STORMWATER MANAGEMENT PLAN (SWMP)

PROJECT: 22A267

**Town of Ramah Wastewater
System Improvements**

DATE: February 6th, 2023

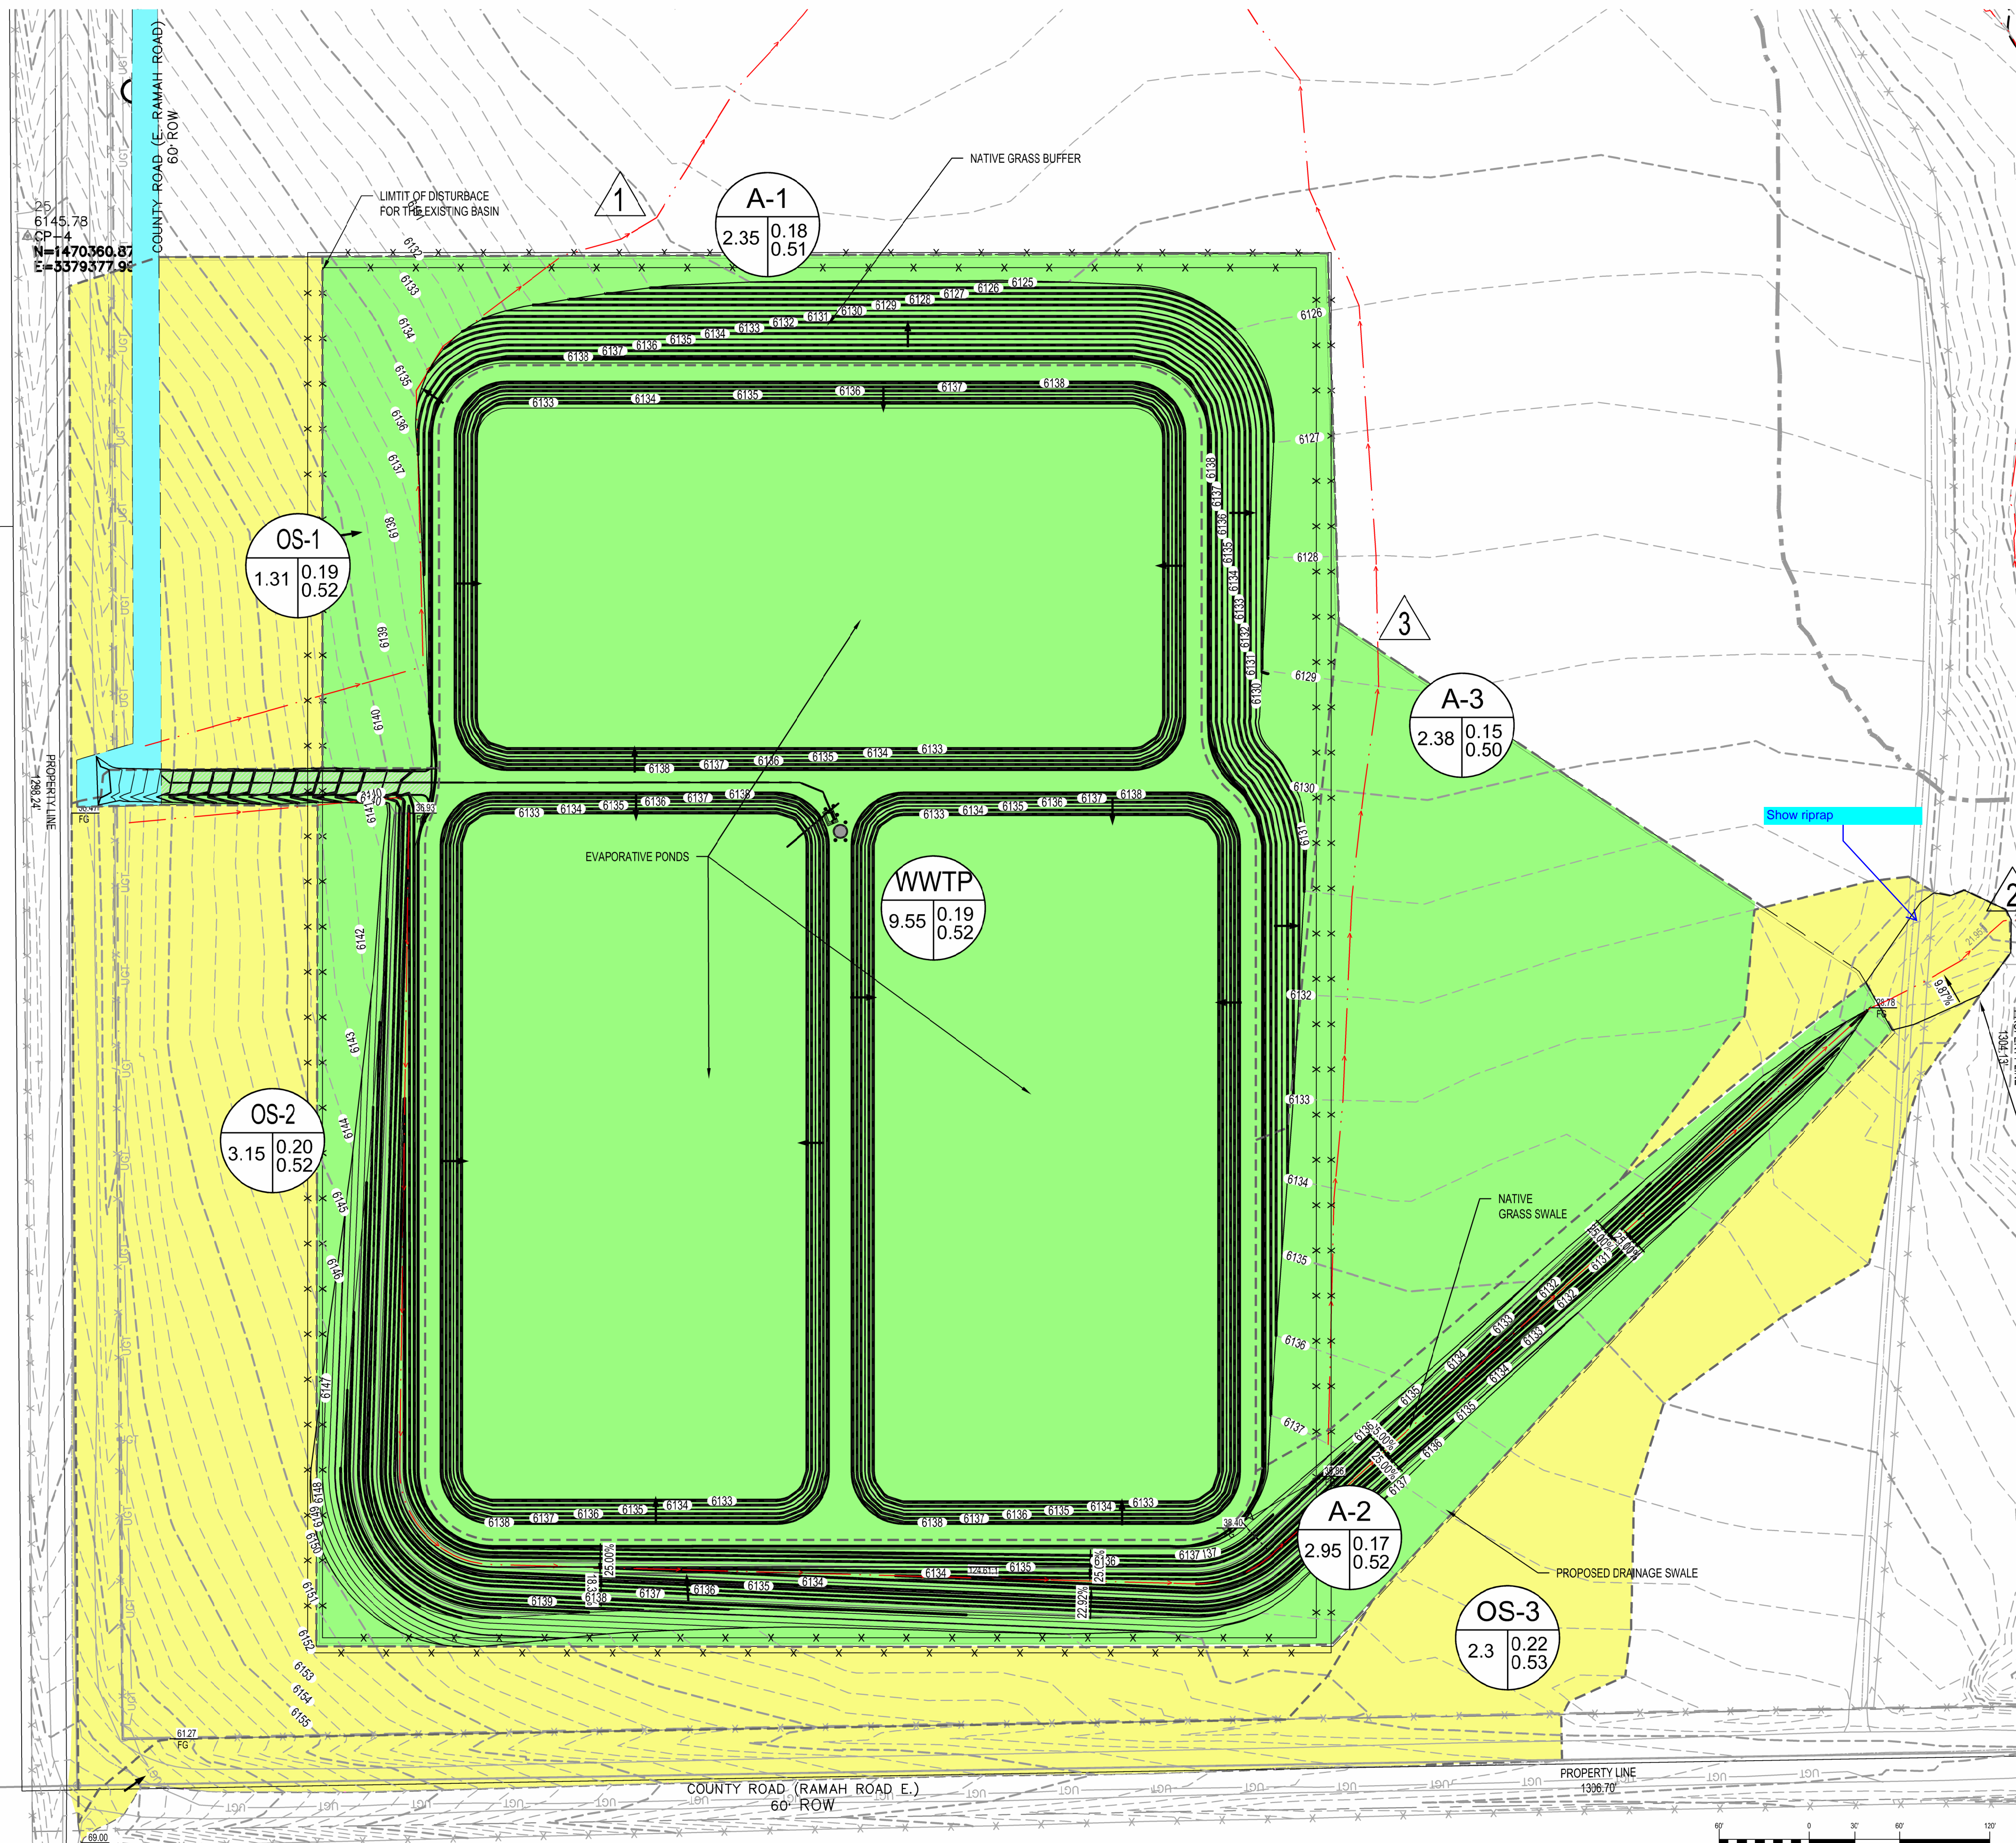
The Geologic Hazard Report also presents erosional features. Discuss the conclusions from that report as well. The report notes an eroding gully to the east of the evaporation pond site and it would be helpful to have that erosion information as well as the NRCS data and HSG classification.
